From: Sue Howell
Sent: 26 July 2017 14:35
To: 'Jenn Mesuria'
Cc: Claire Potts; Mail; Annelies Earley, [REDACTED]; Slingo, Bradley
Subject: RE: Planning Consultation on AL/11/17/DOC. BDWS20440 Hook Lane, Westergate

This application is looking for the discharge of Condition 12 of application AL/11/17/DOC imposed under AL/39/13 Landscaping.

The information provided in substitute landscape proposal plans BDWS20440 11G sheets 1-4 do contain a well thought out scheme which is suitable for location and which is sufficient in detail in plan form. However the open space areas plan 160104/OS Rev C and substitute detailed play area proposals dwg BDWS

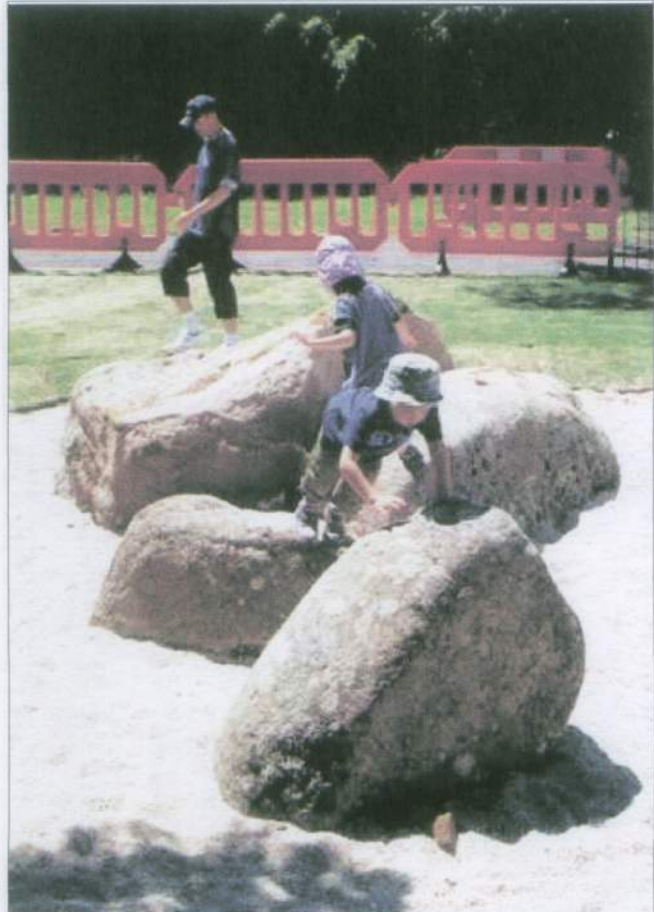
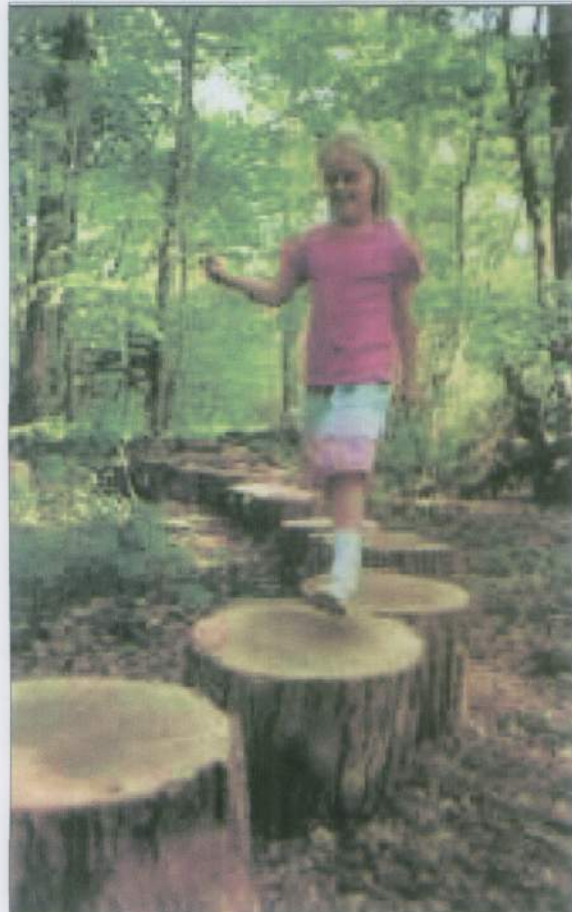
20440 20B conflict with these drawings in that they show a different location layout. We would recommend that the open space and play drawings are amended to show the correct layout and how these connect with the pathways which the information lacks at present. We note the proposal to fence the play area because of the proximity to balancing pond and would again recommend that this subject to a ROSPA inspection.

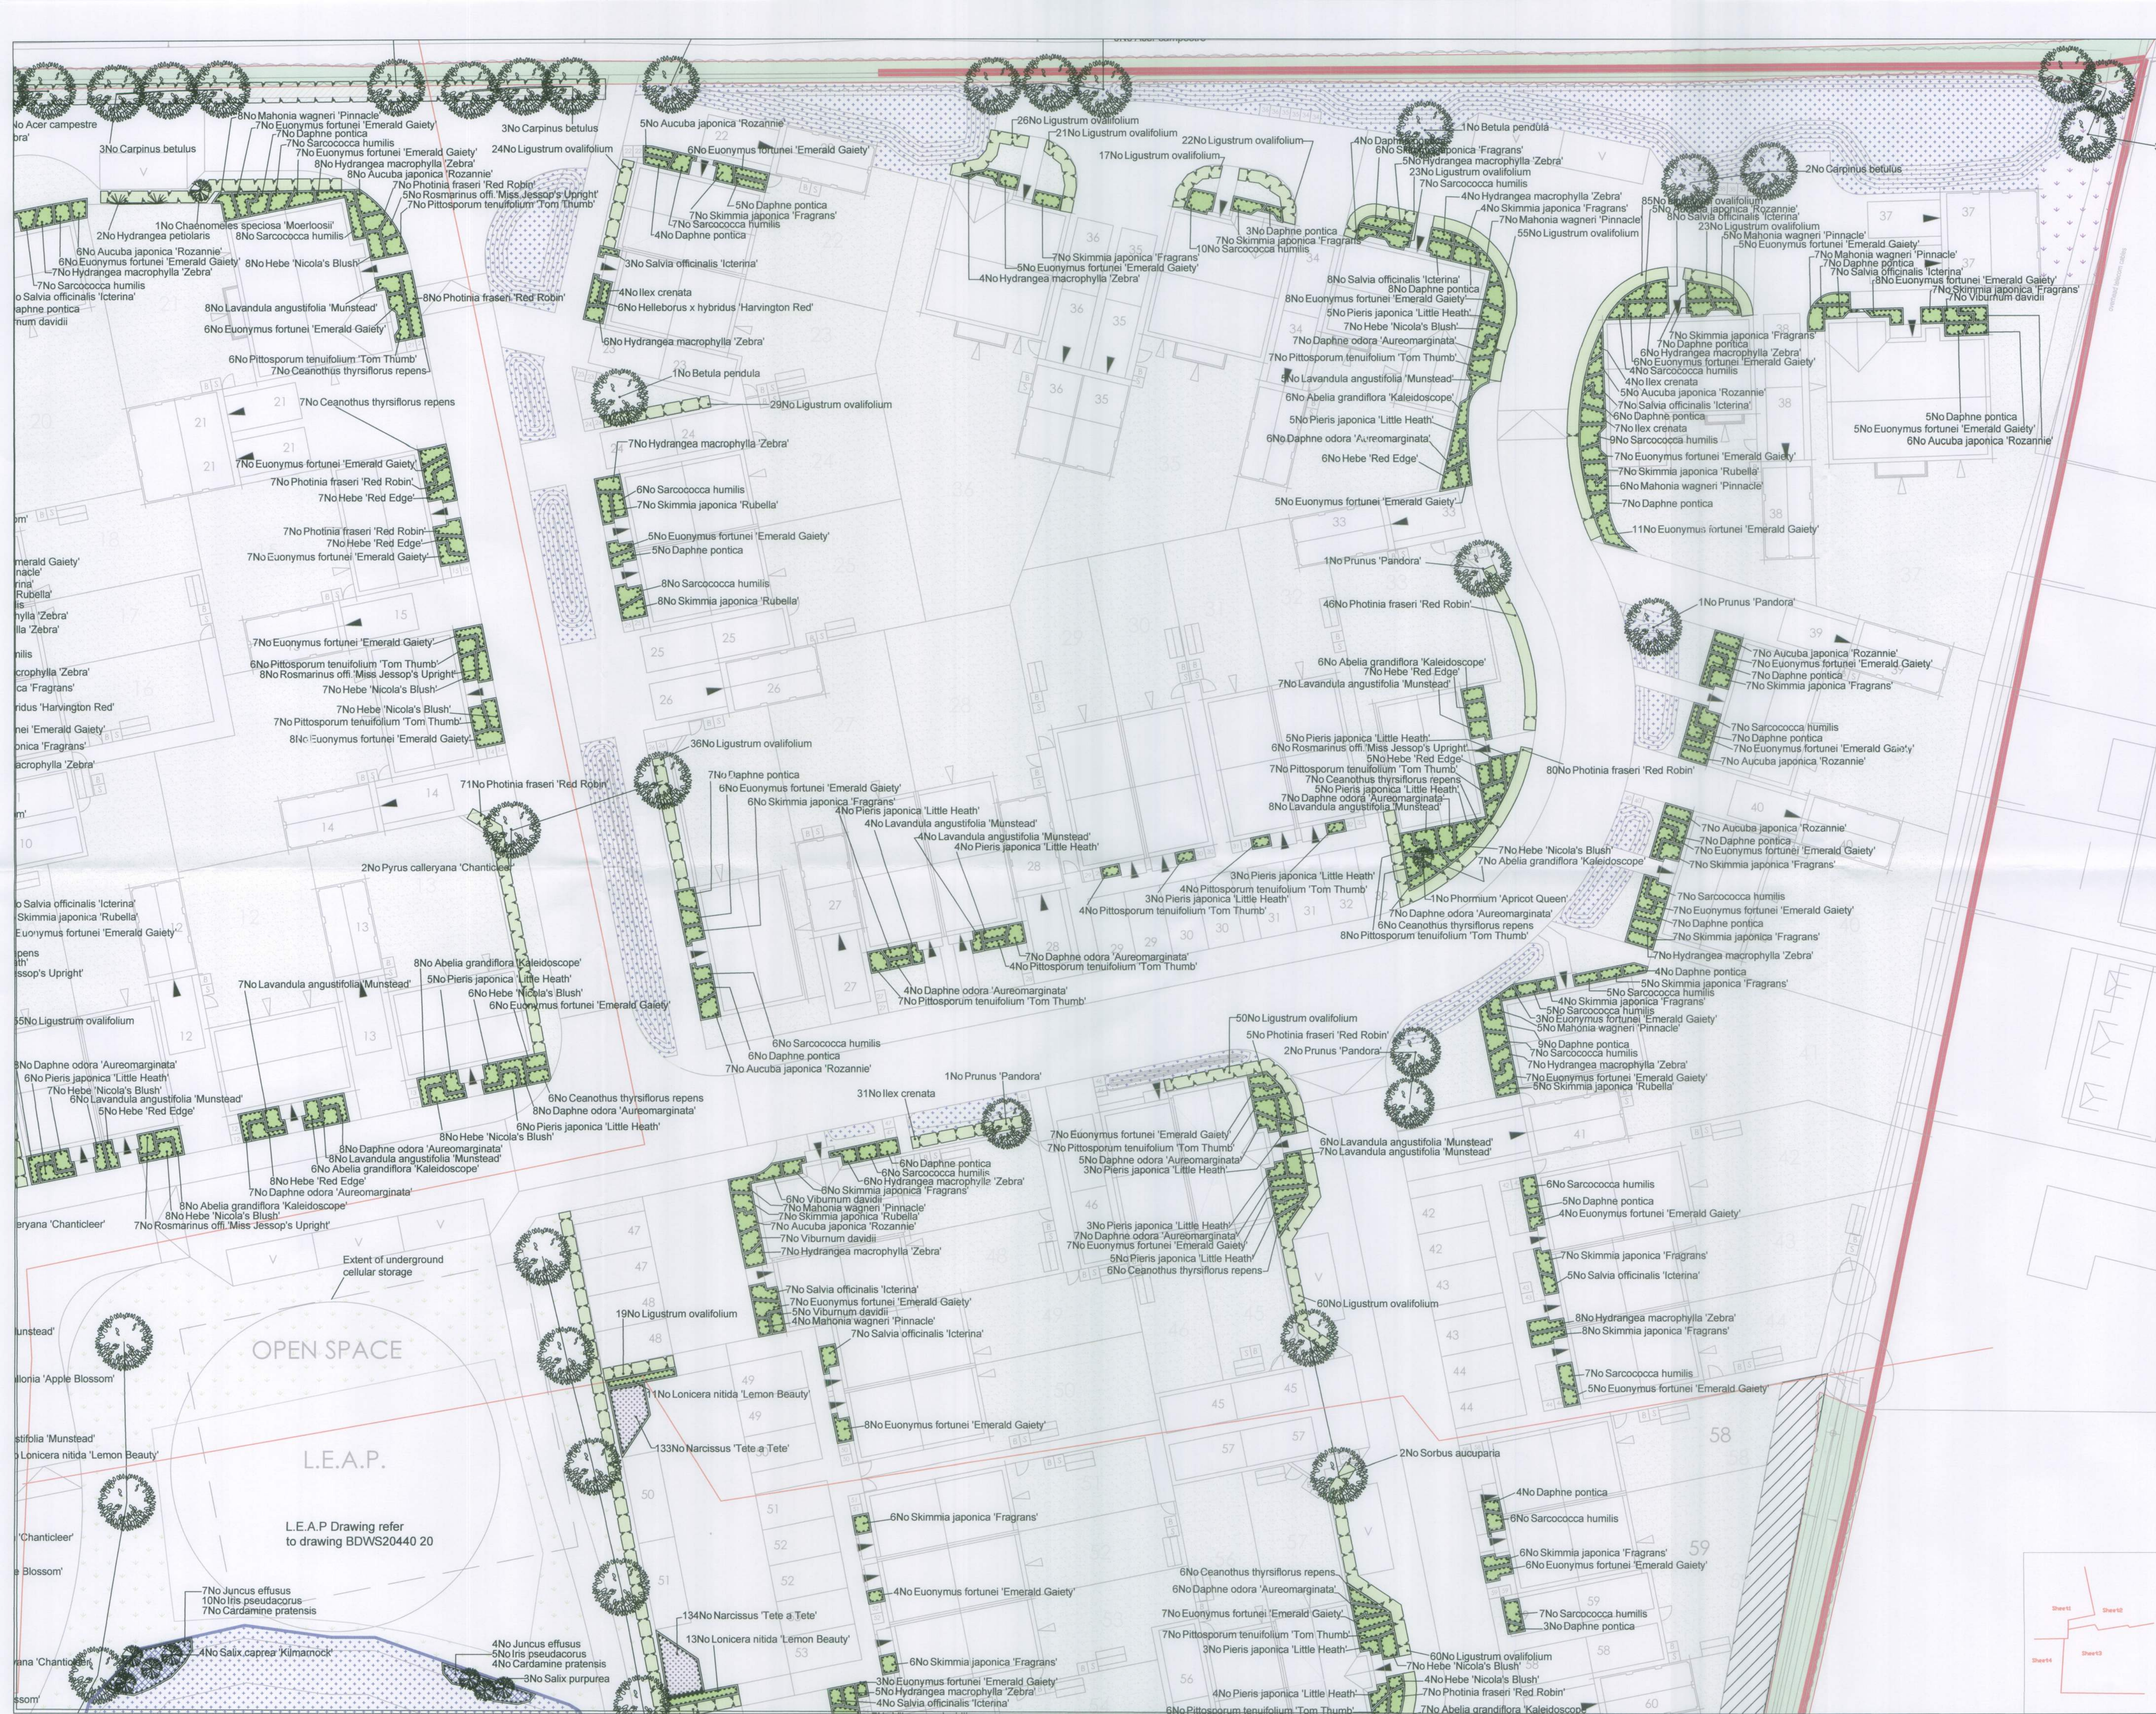
Regarding your comments – we just wanted to confirm that we should add the updated play area outline (remove the circle) and add footpaths to our BDWS20440 11 drawings?

The updated soft landscape proposals plan now includes the revised information that I had flagged previously as requiring revision.

Please find attached our updated soft landscaping proposals. I have included all sheets for consistency.
